**Response to Submissions  
– Planning Reference  
ACP-323873-25**

Kingston Park and Millers  
Lane – Public Park and  
Urban Realm Project

Client: **Galway City Council**

Drawing file: Lighting / 24.2812 P-E103 Millers Lane_Multi Sport Pitch Lighting.pdf

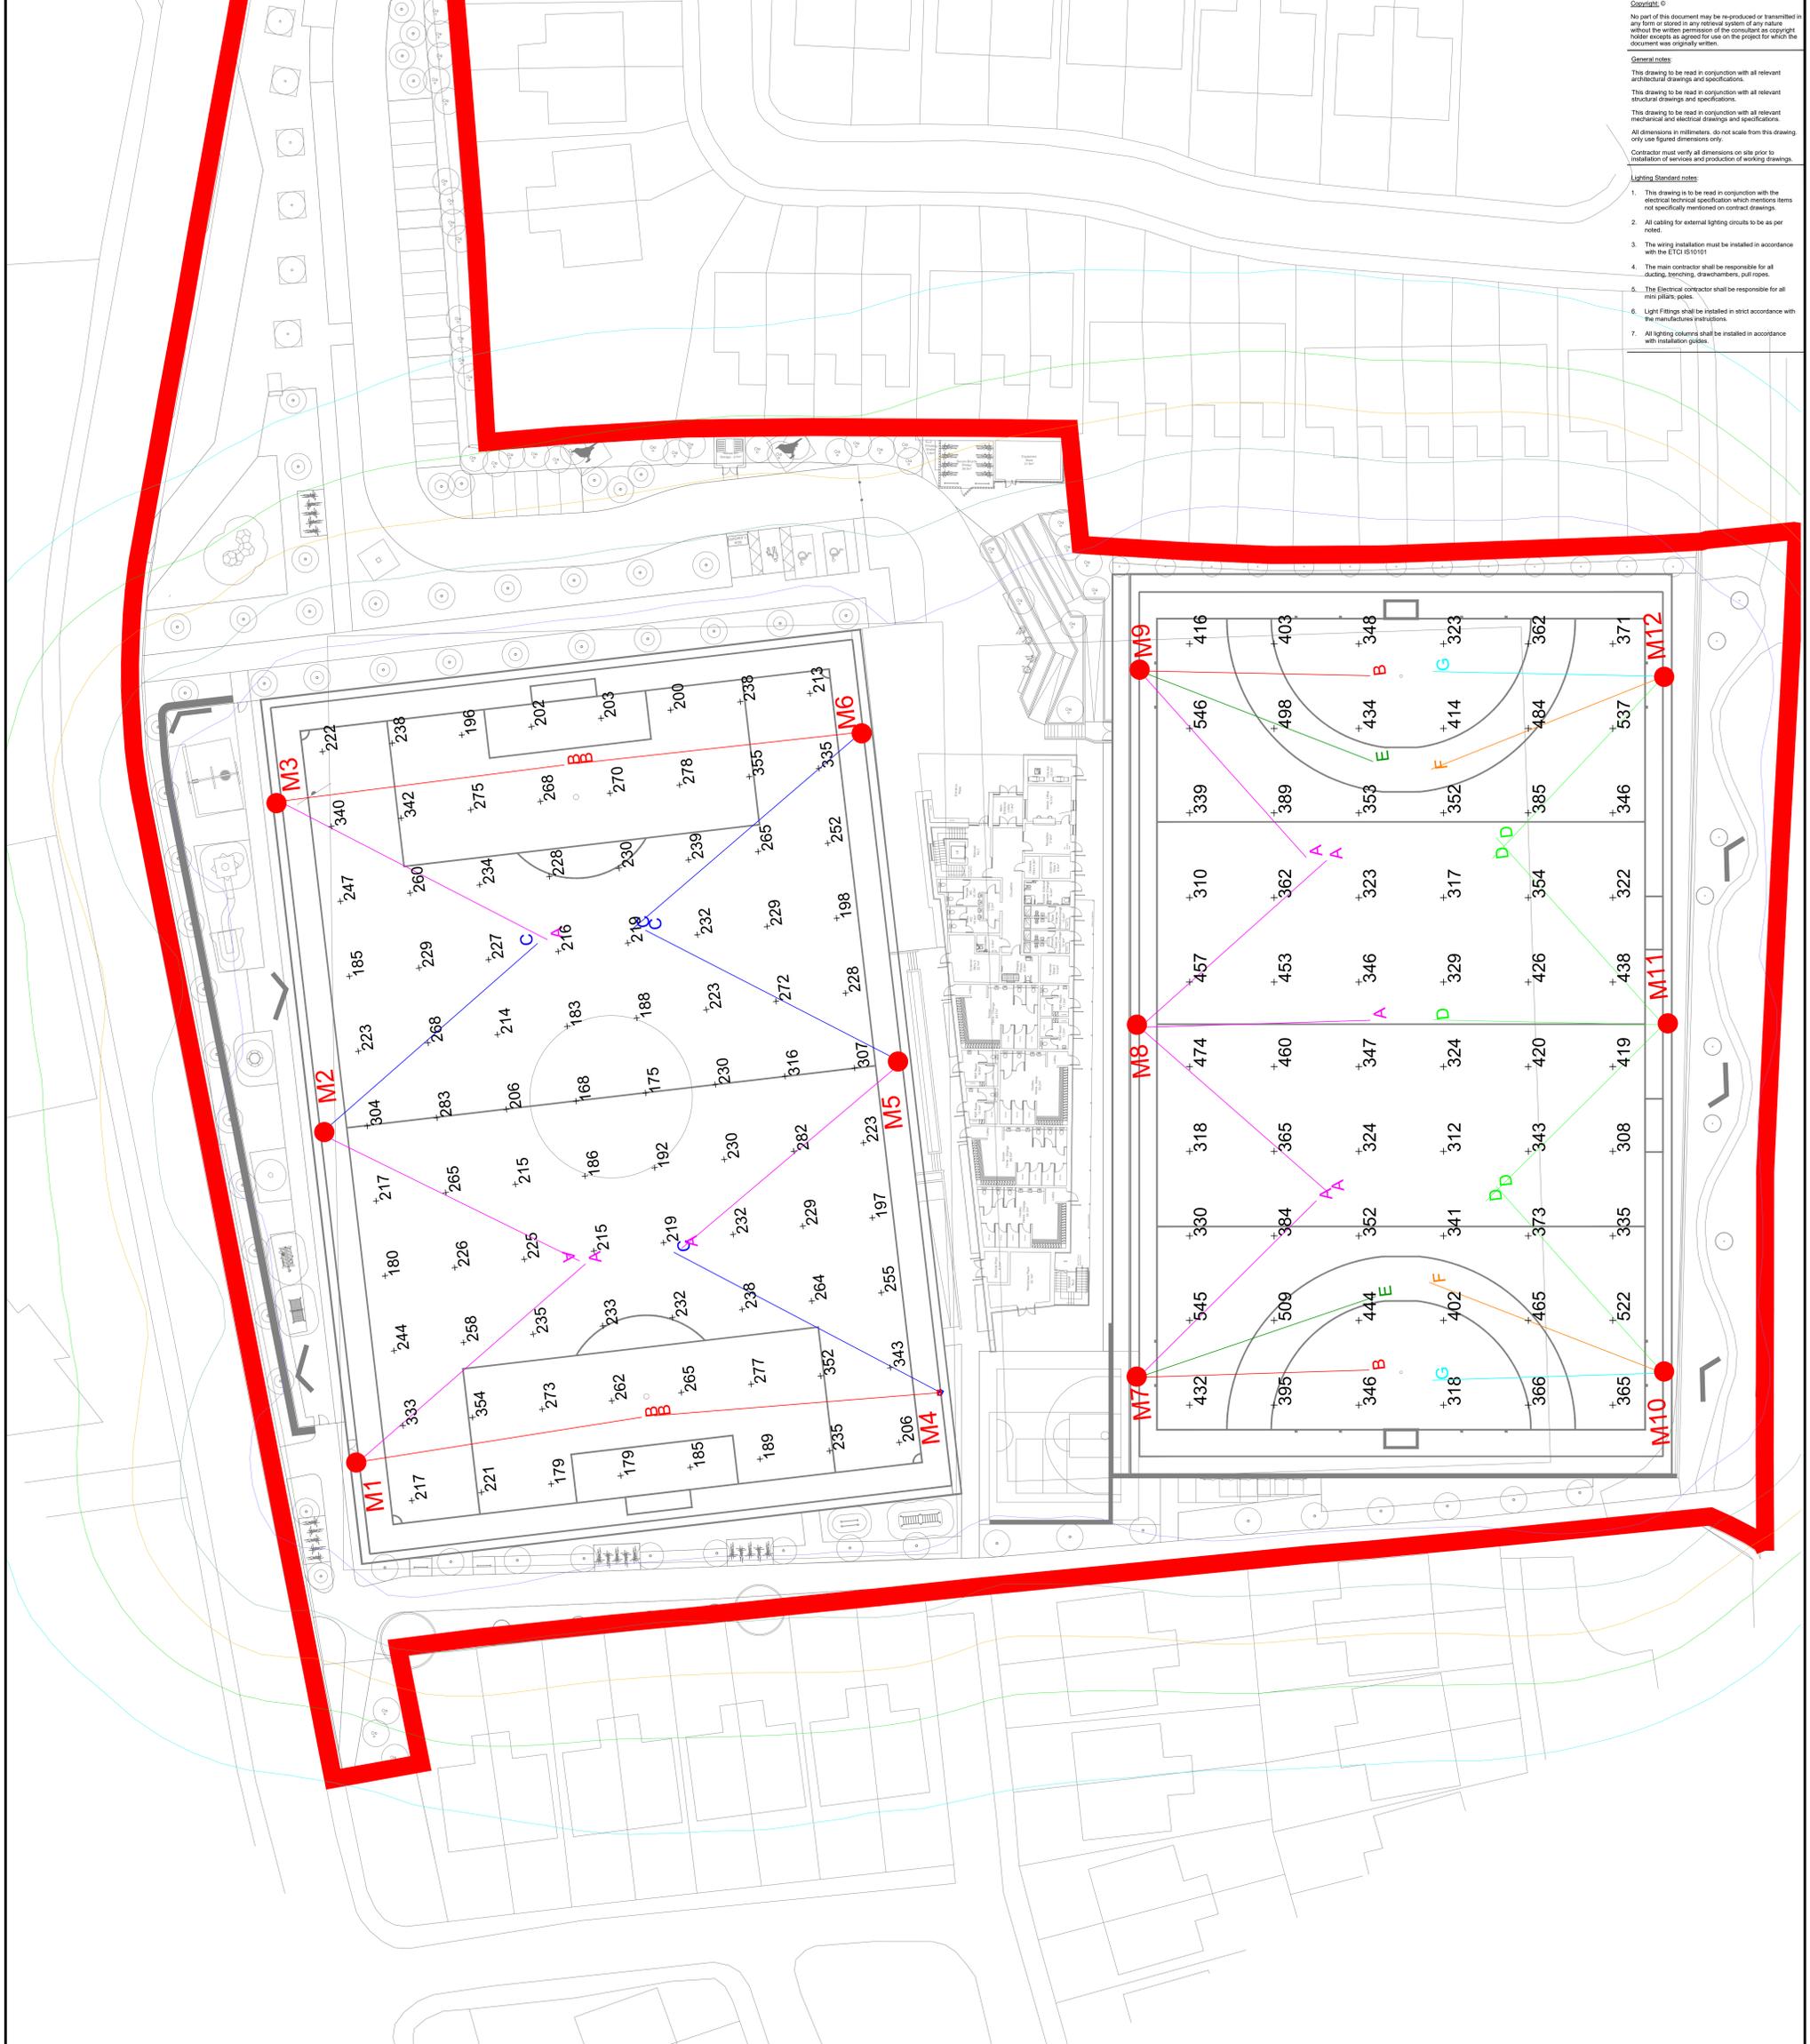
- The potential impact of the proposed floodlights on residential amenity.
- The proposed hours of operation of the café, and queries regarding whether a drinks licence will be associated with the facility.
